PROJECT # 1002357  
**M-15 / D 39**

PROJECT TITLE: RNG, LLC, OFFICE/SHOP ZONE MAP/DRG. FILE #: M-15 / D 39  
DRB #: 03 DRB. 00287 (SOP) PC#: 02876 - 01767 WORK ORDER#:

LEGAL DESCRIPTION: LOT 11, N2 COMMERCIAL OFFICE CENTER  
CITY ADDRESS: 1710 RANDOLPH COURT S.E.

SITE LAYOUT PLAN
DETAILS
TRAFFIC CIRC LAYOUT

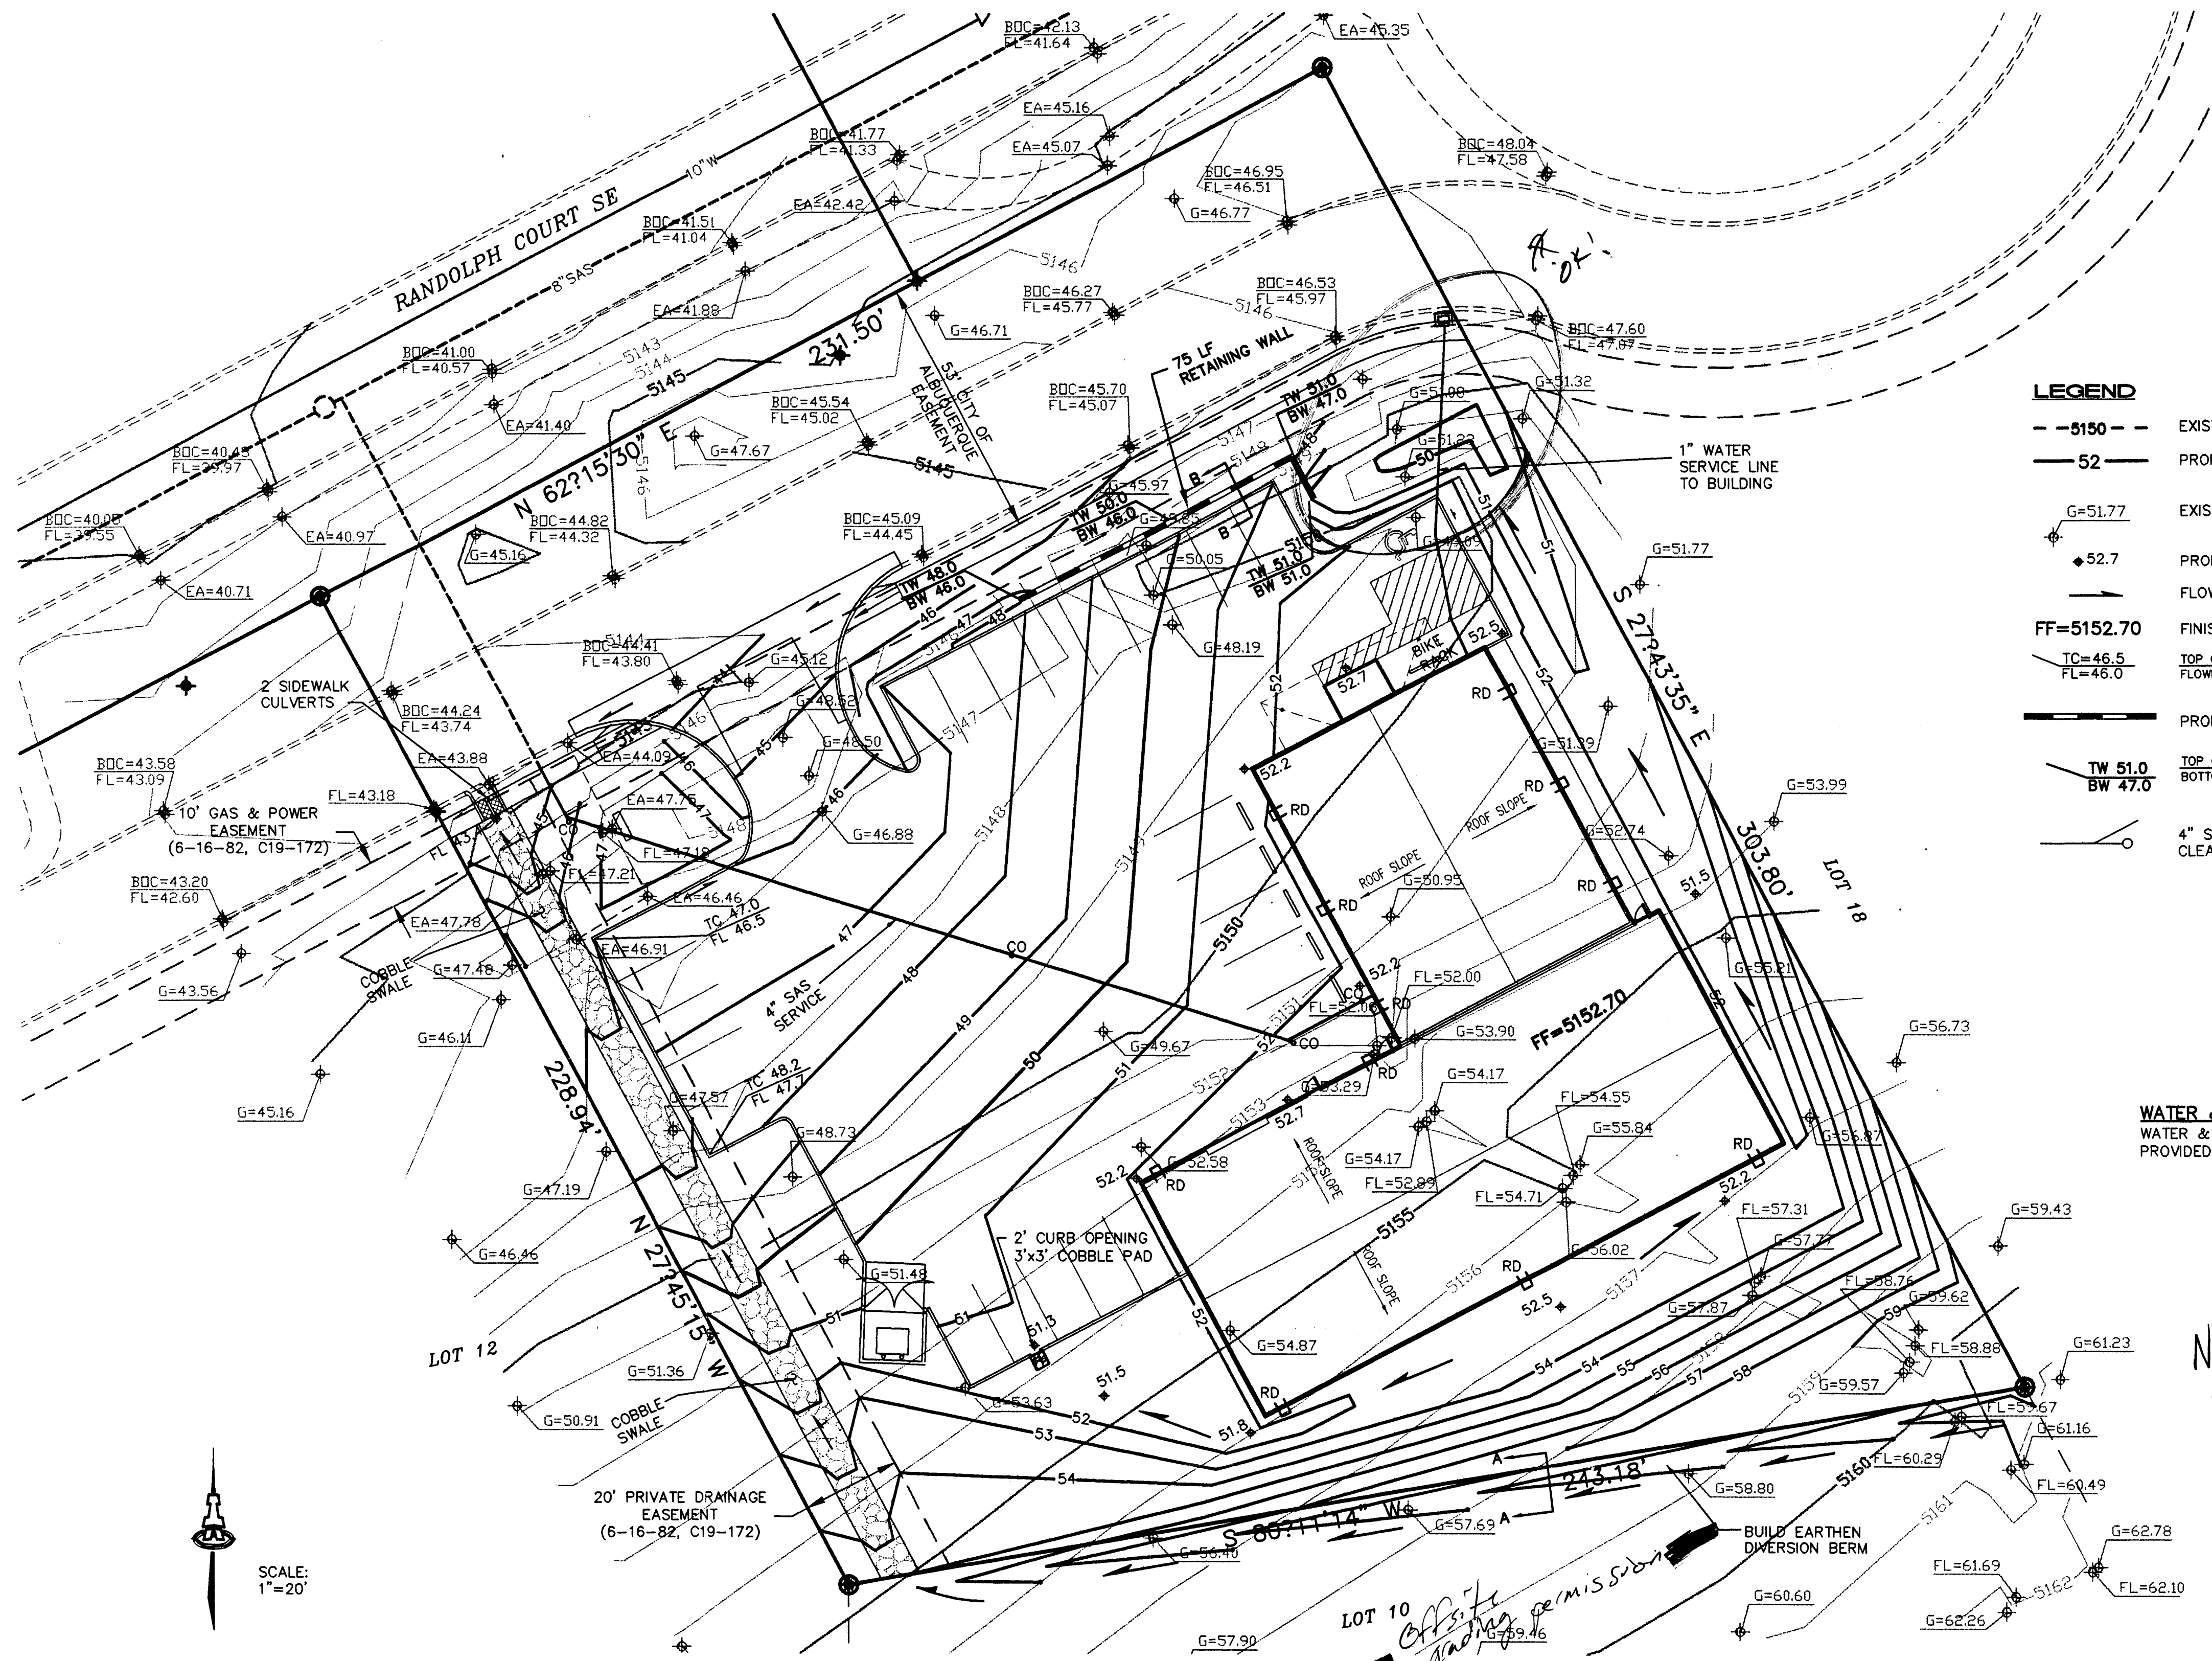
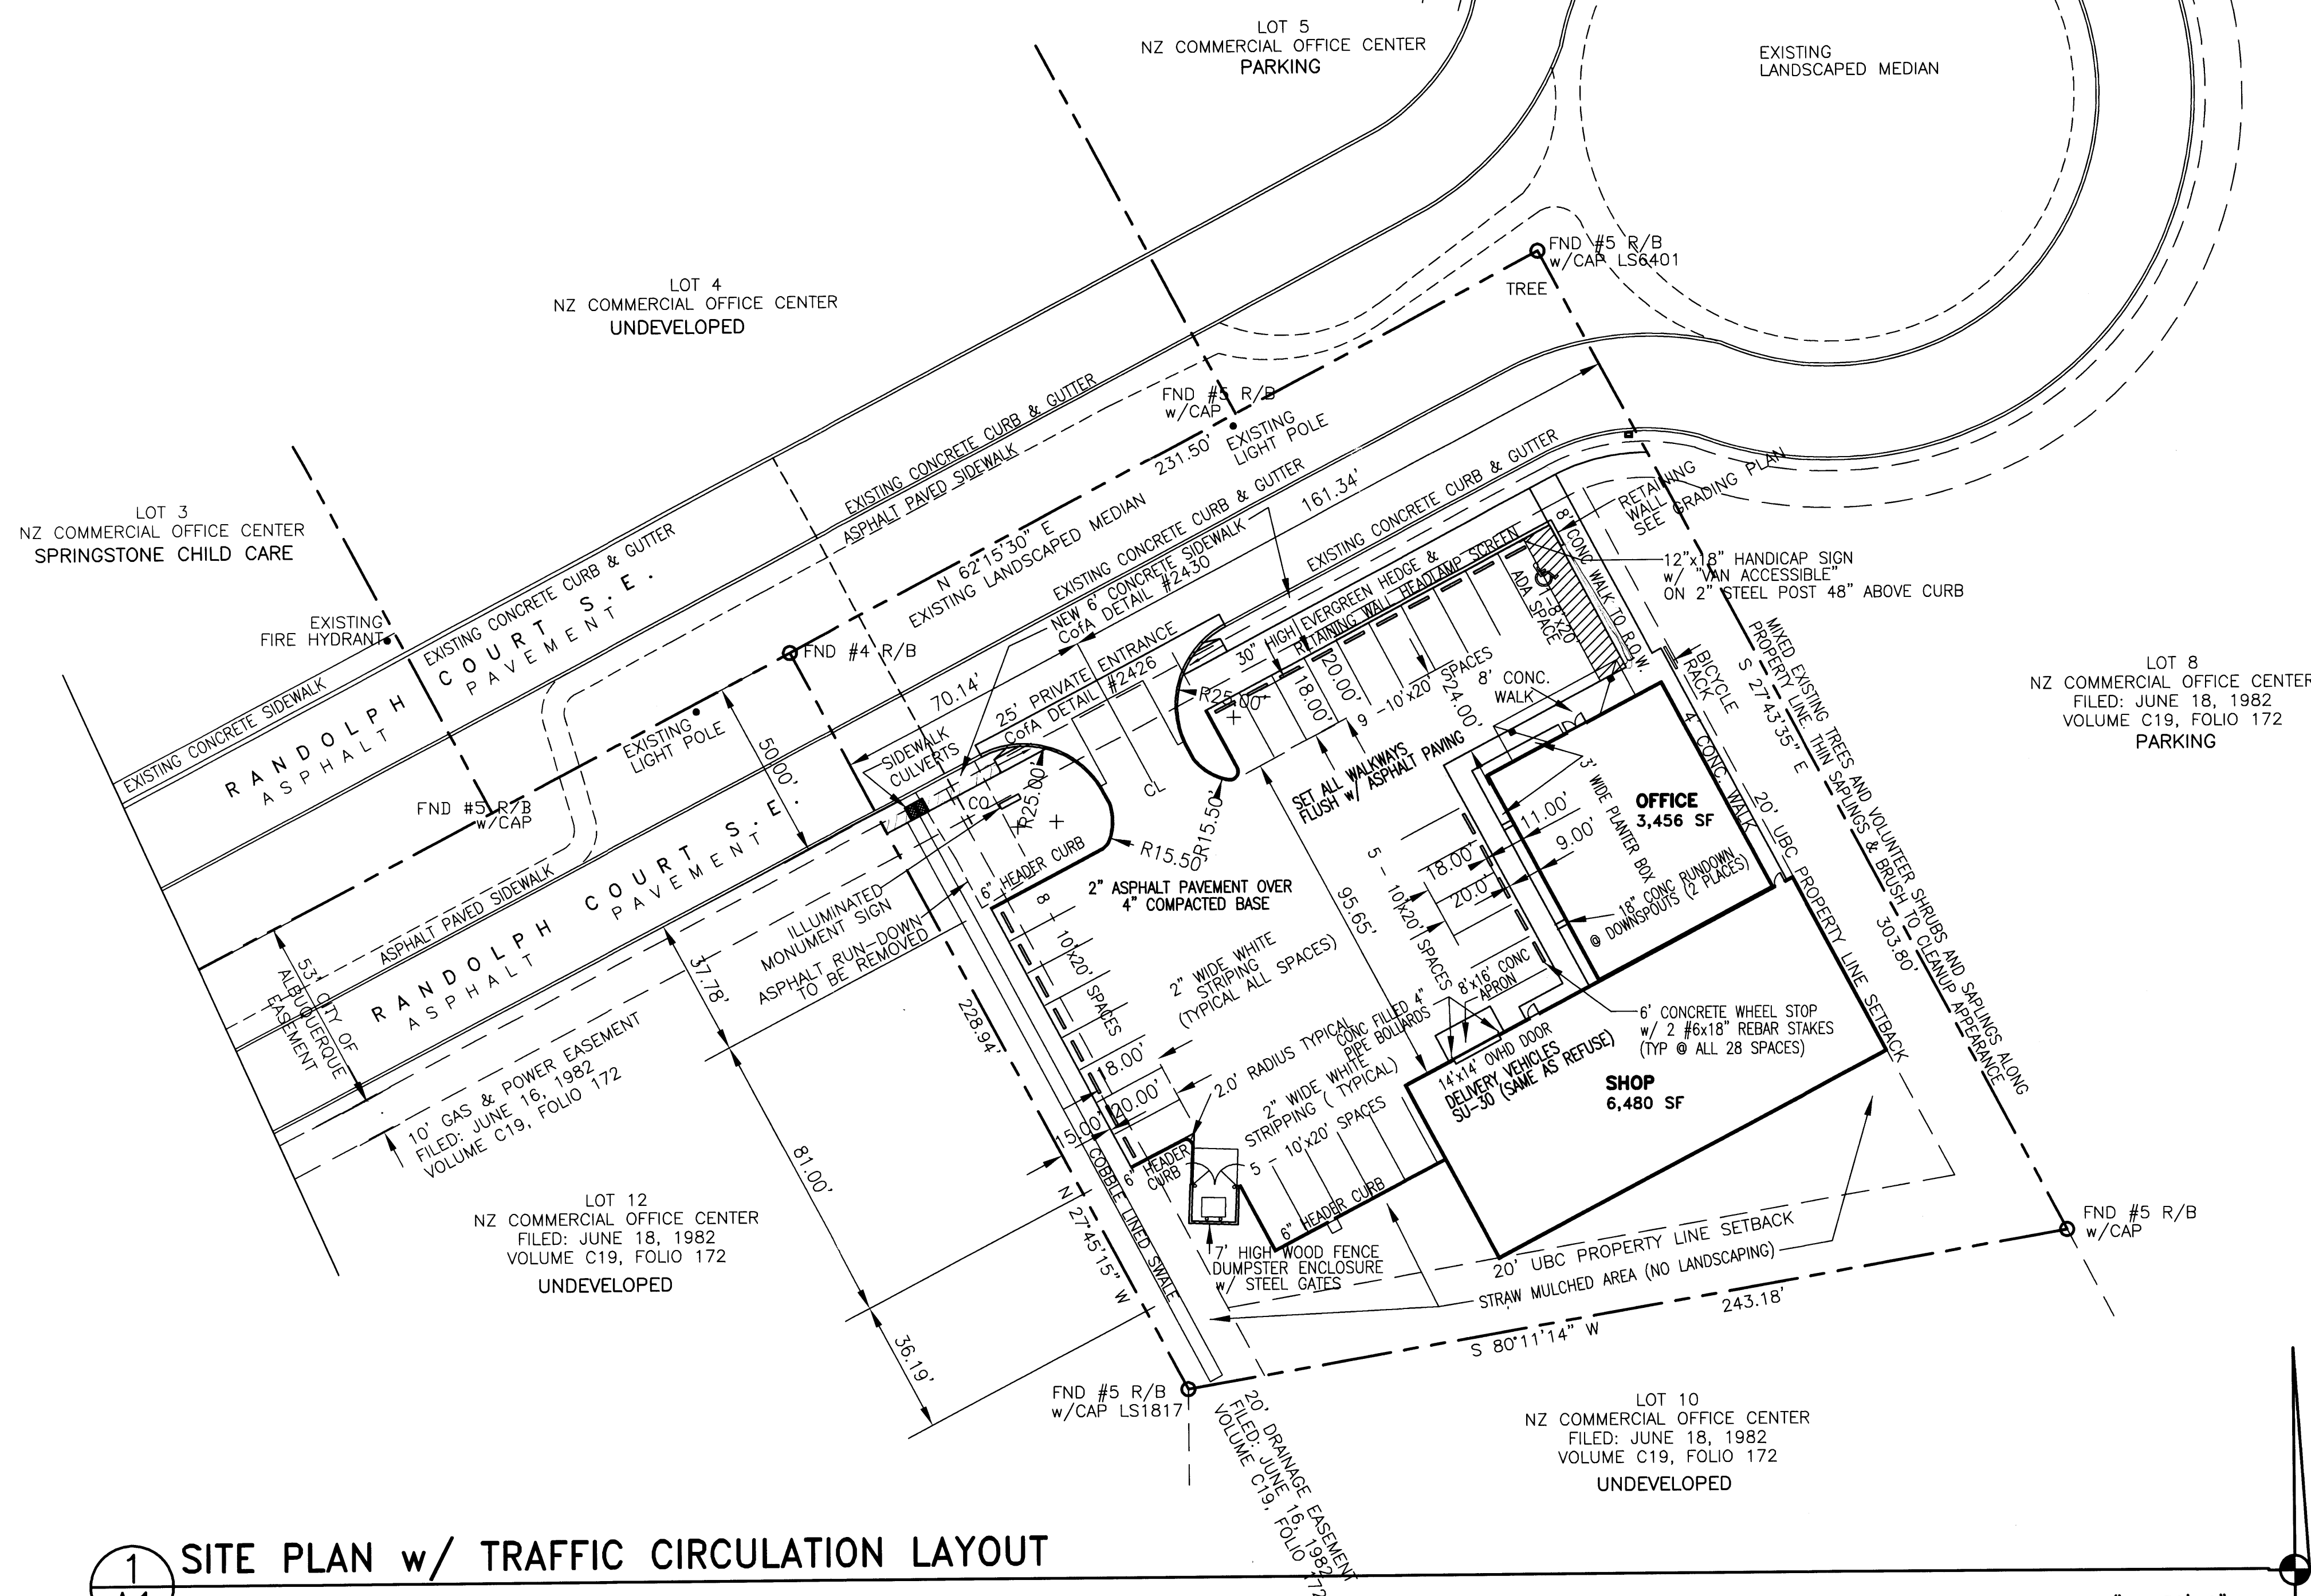
1. Please date your stamp for the next submittal.
2. It appears that the new sidewalk is not located in the 53 foot City of Albuquerque easement.
3. Please place curbing between landscaping and the asphalt parking if needed.
4. Please place curbing east of the ADA space and next to the 8-foot concrete walk. This curbing would be used to protect people on the 8-foot walk from vehicles backing up.
